The Planning Inspectorate

Our ref: XA/2025/100270/03-L01

Your ref: EN010152

Deadline 2 – Environment Agency responses to The Examining Authority's first written questions (ExQ1).

Access Drawing Botley West
Gate No. 4 (Gate ID: MN-G4)

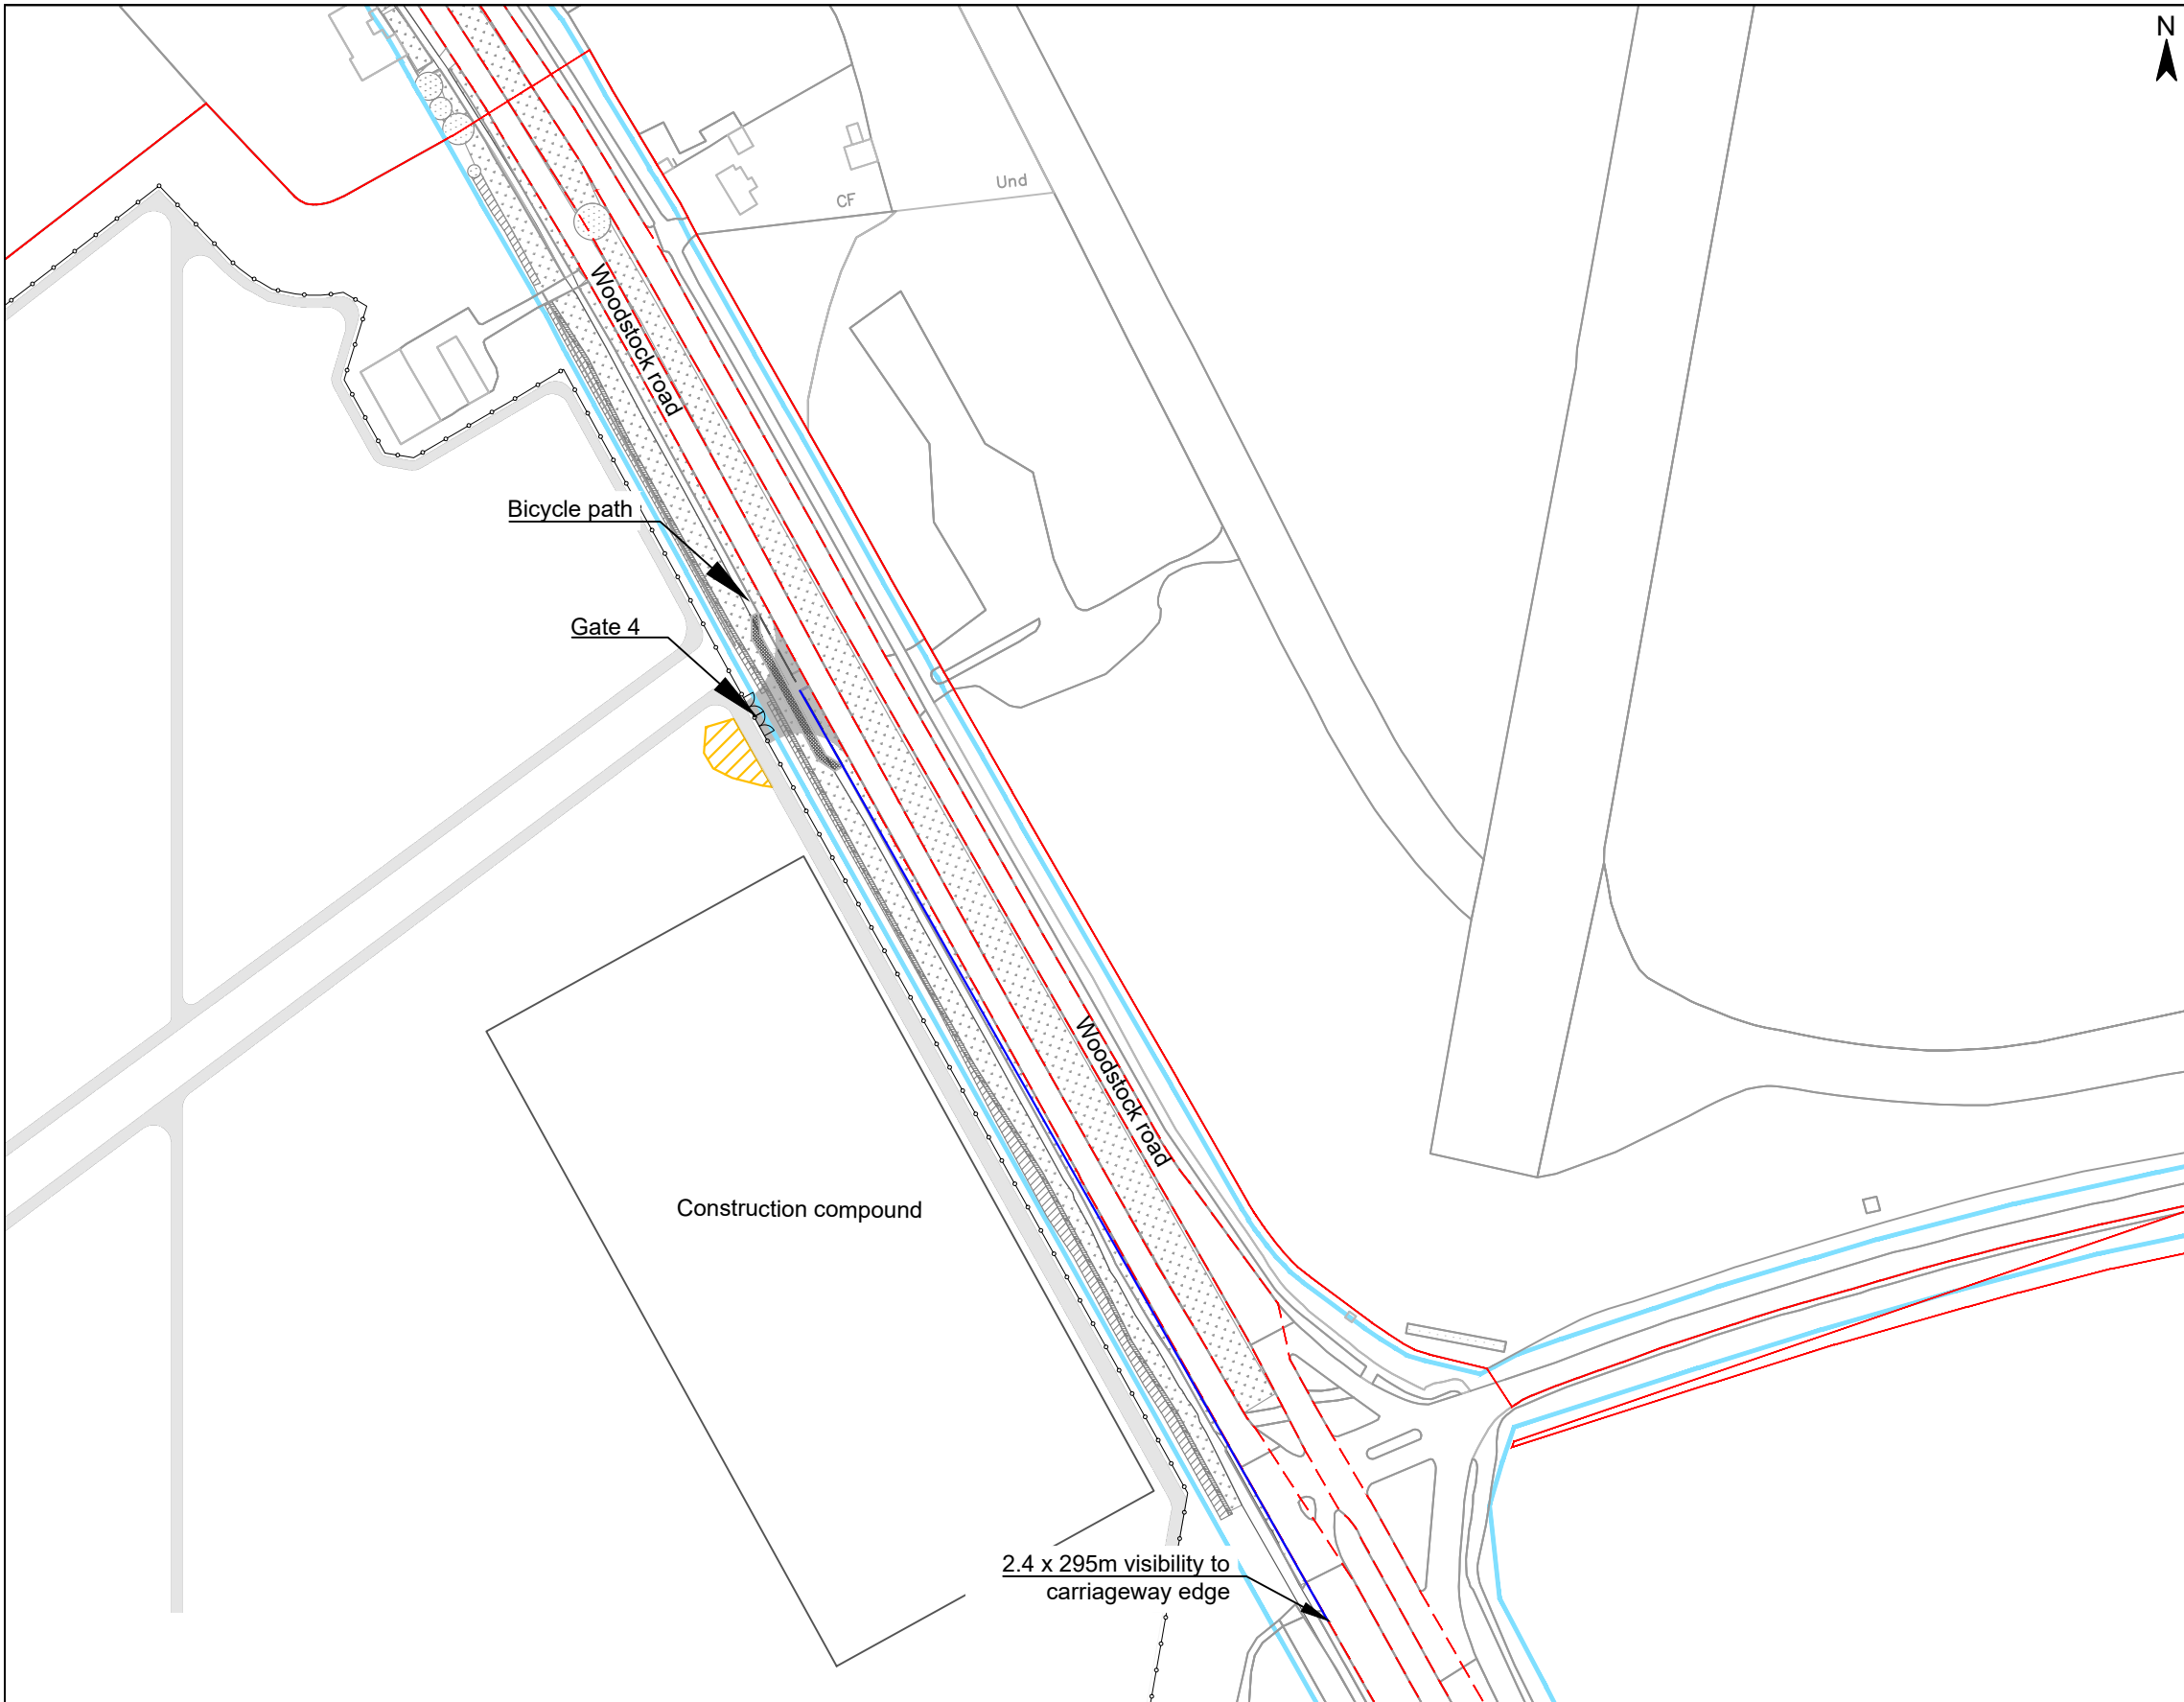
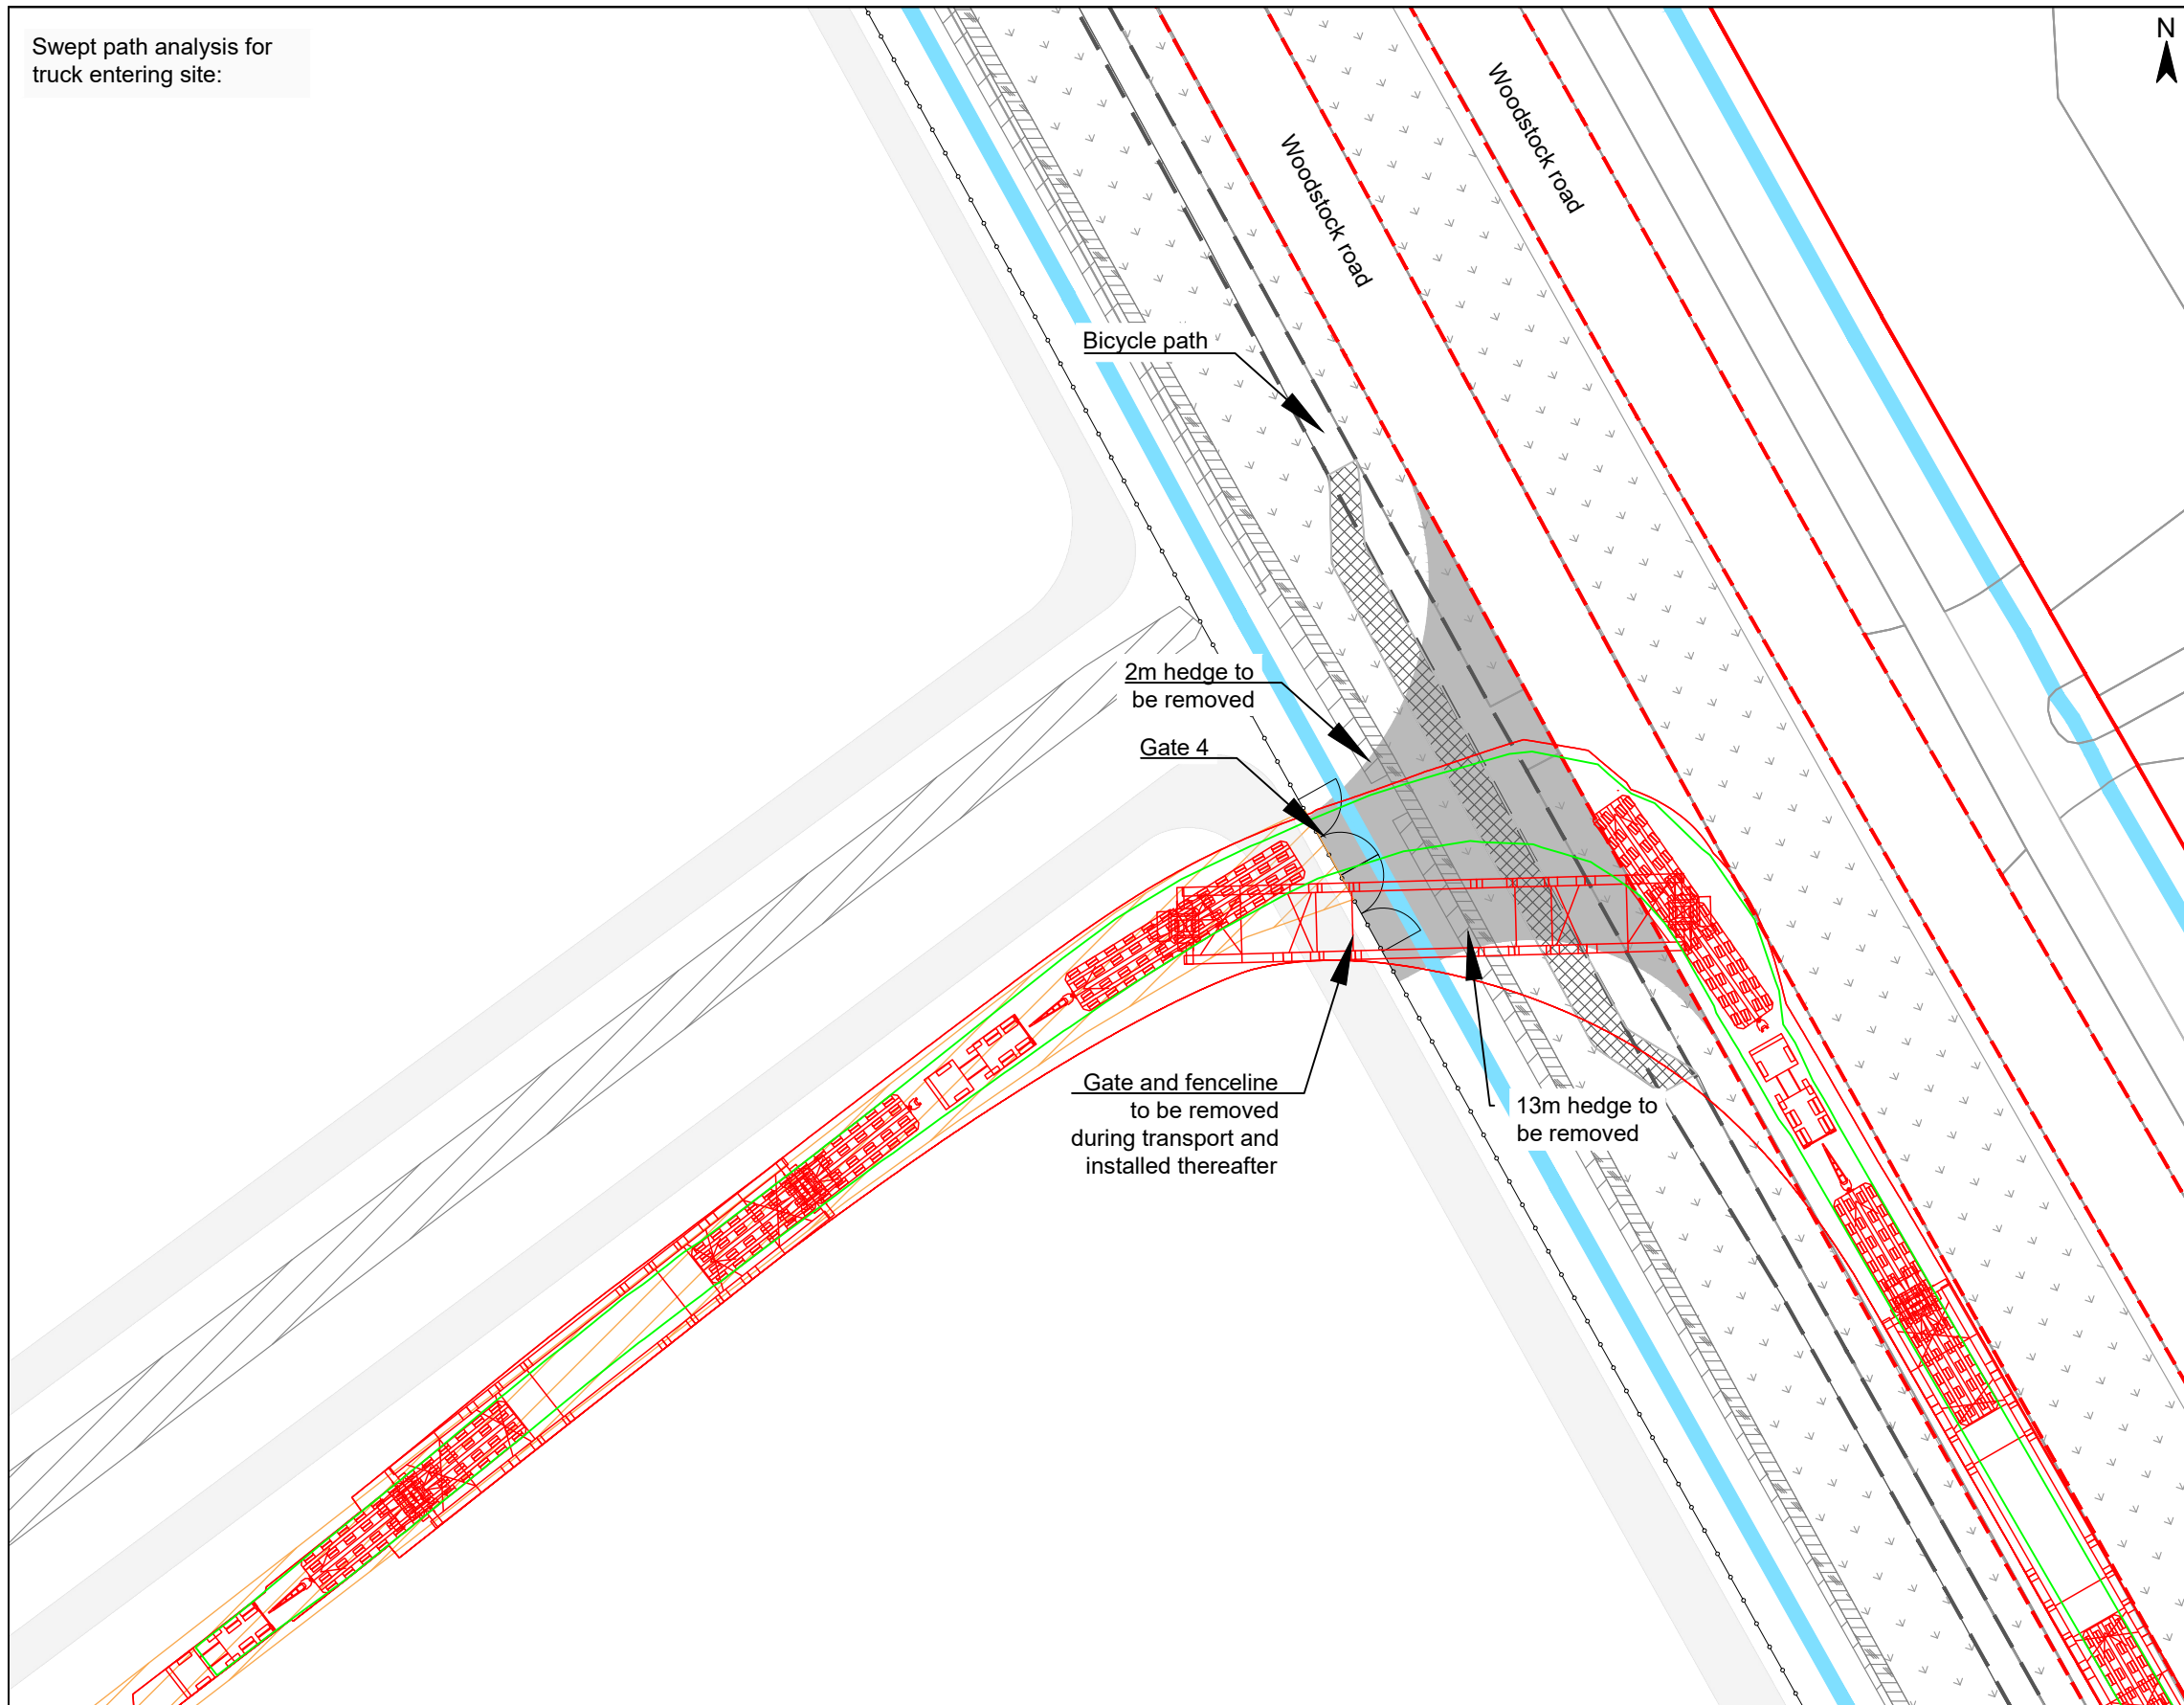
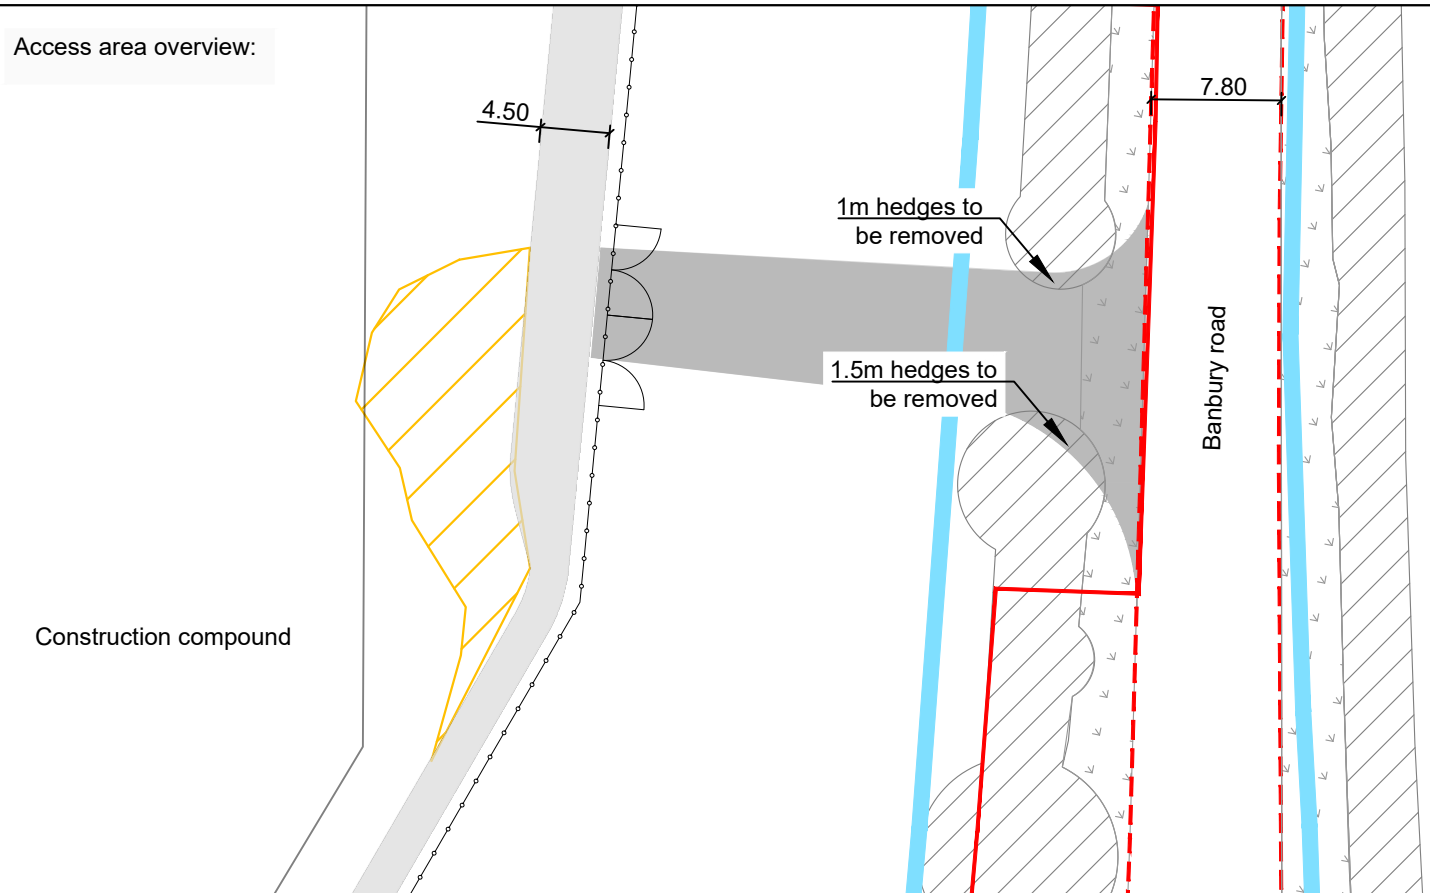
Clarify if hard surfaces and maintenance are existing or new, and whether the Applicant will manage any runoff.

Proposed embankment works should not inhibit flood flow routes. May require CFS if within the design flood extent.
